Development Control
Ribble Valley Borough Council

App no: 23.0374

Address: Dilworth Coach House 41 Dilworth Lane Longridge

Proposal: Conversion of existing garage into a two-bedroom dwelling including new front porch, new access and vehicular parking for 41 Dilworth Lane.

JOB NO. 3360  
DRAWING NO. 005  
REVISION D  
SCALE 1:200 @ A3

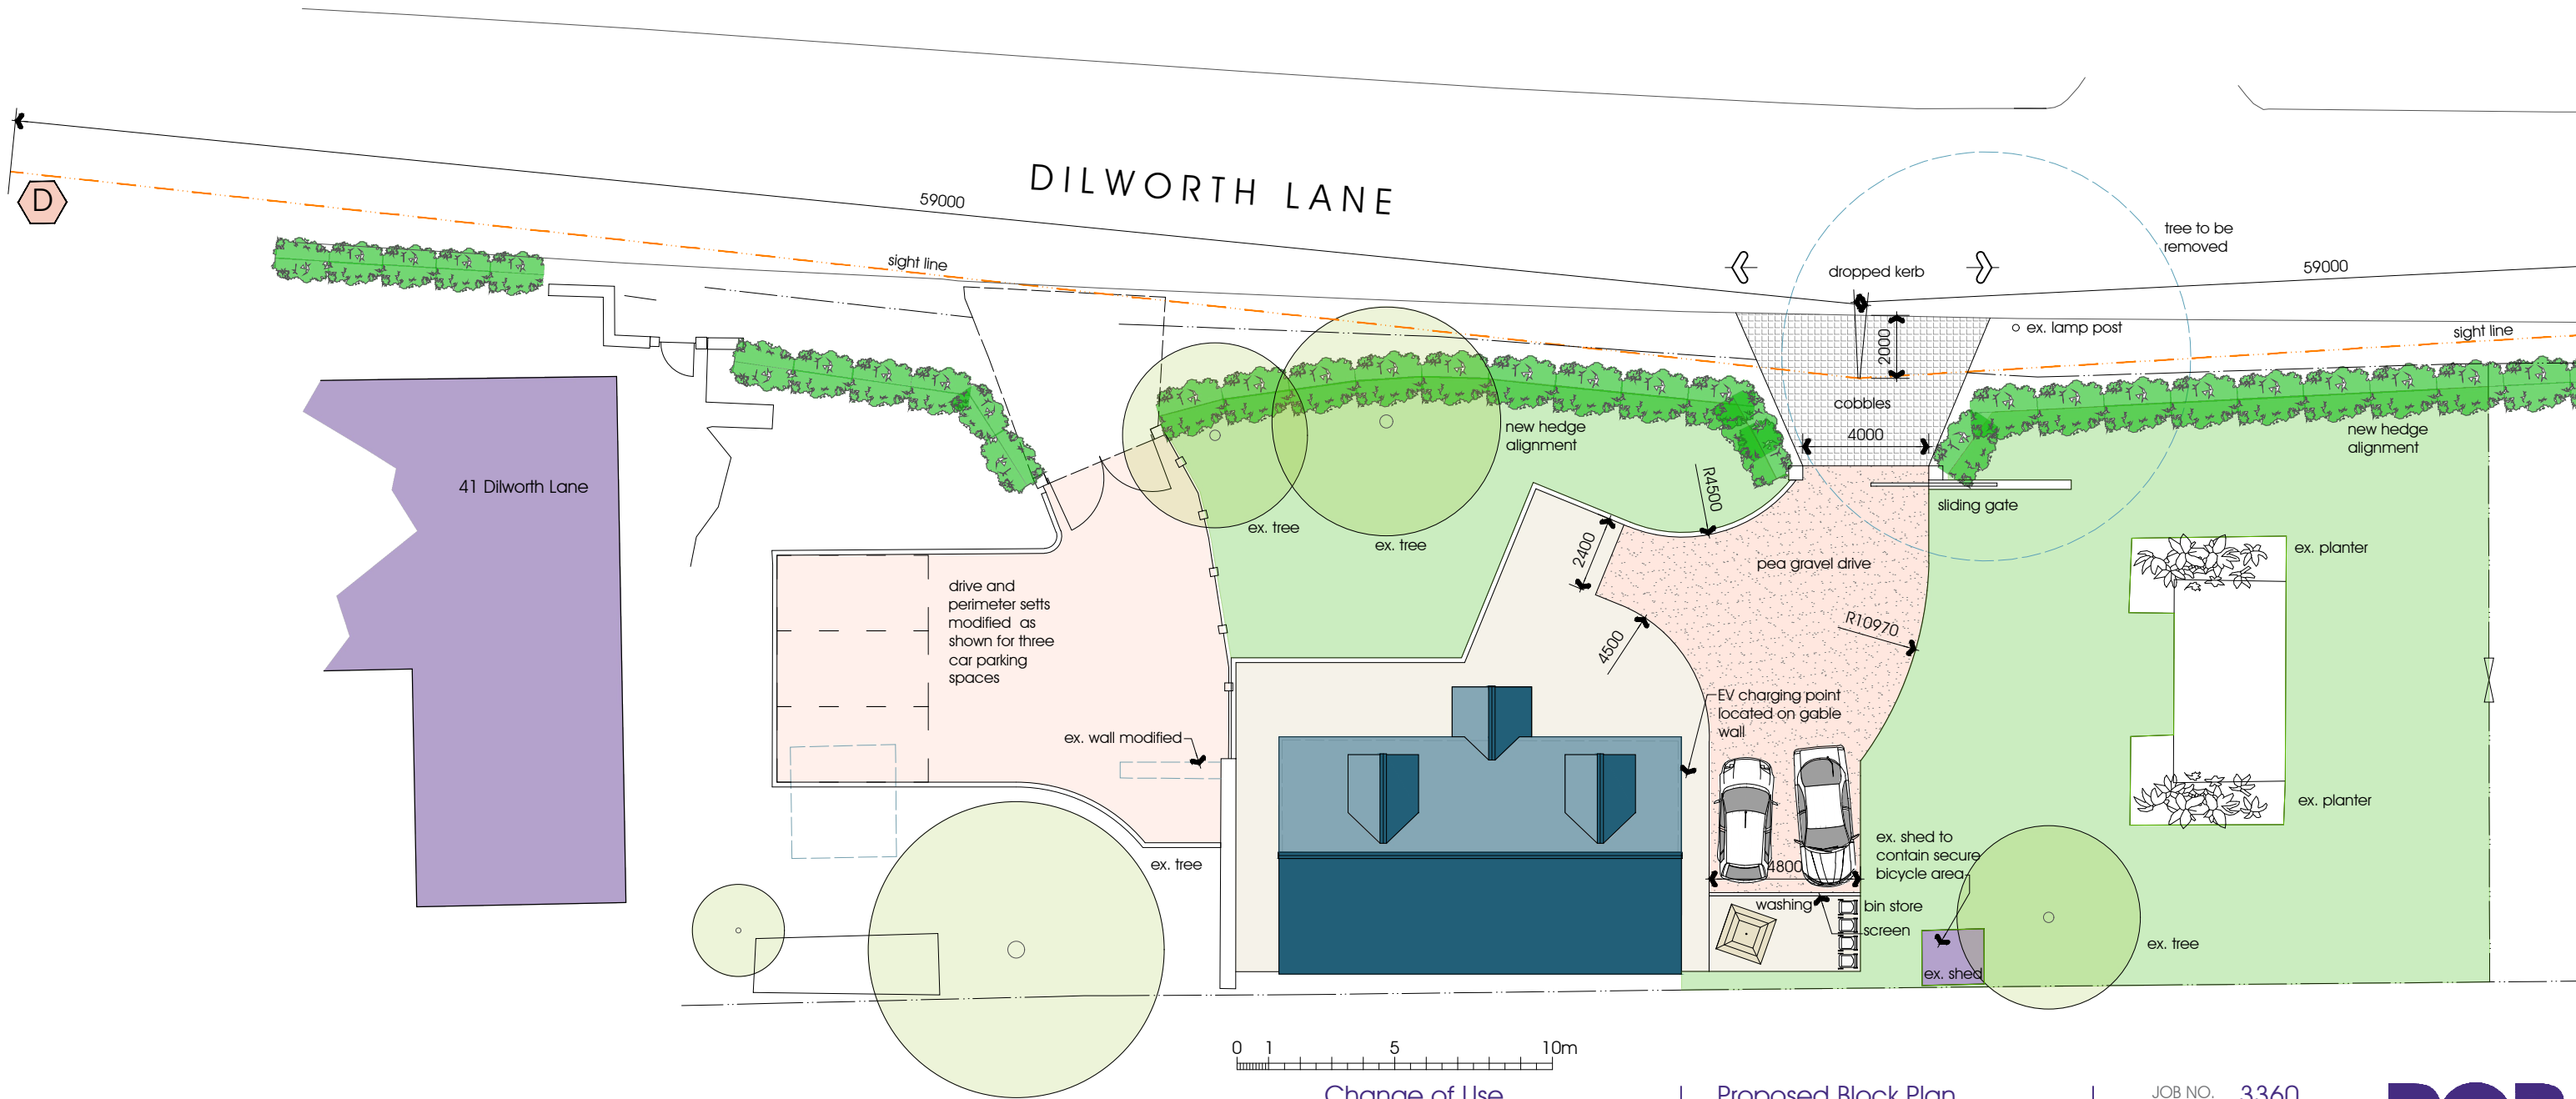
A new access is proposed on Dilworth Lane for the proposed new 2-bedroom dwelling. The access is 4m wide with gates set back 5.5m from the carriageway of Dilworth Lane, visibility splays x distance 2.4m by y distance of 40m in both directions is indicated on the drawing.

To create the access and visibility splay the hedge will be re-aligned and one tree removed.

Application 3/2016/1201 for the erection of a new dwelling to the east side of the application site provided a traffic count which recorded 85thile vehicle speeds of 39mph in both directions. Therefore, visibility splays of x-2m by Y-59m were provided. The same splays should be provided for the new site access sought under this application. Due to the lack of footway along the site frontage the splays can be off-set from the kerb edge by 1m. The Highway Authority expects that the amended visibility splays can be achieved.

Secure cycle parking and electric vehicle charging will be required.

For completeness we would request that the visibility splays are amended on drawing PGB-3360-005-Rev C.
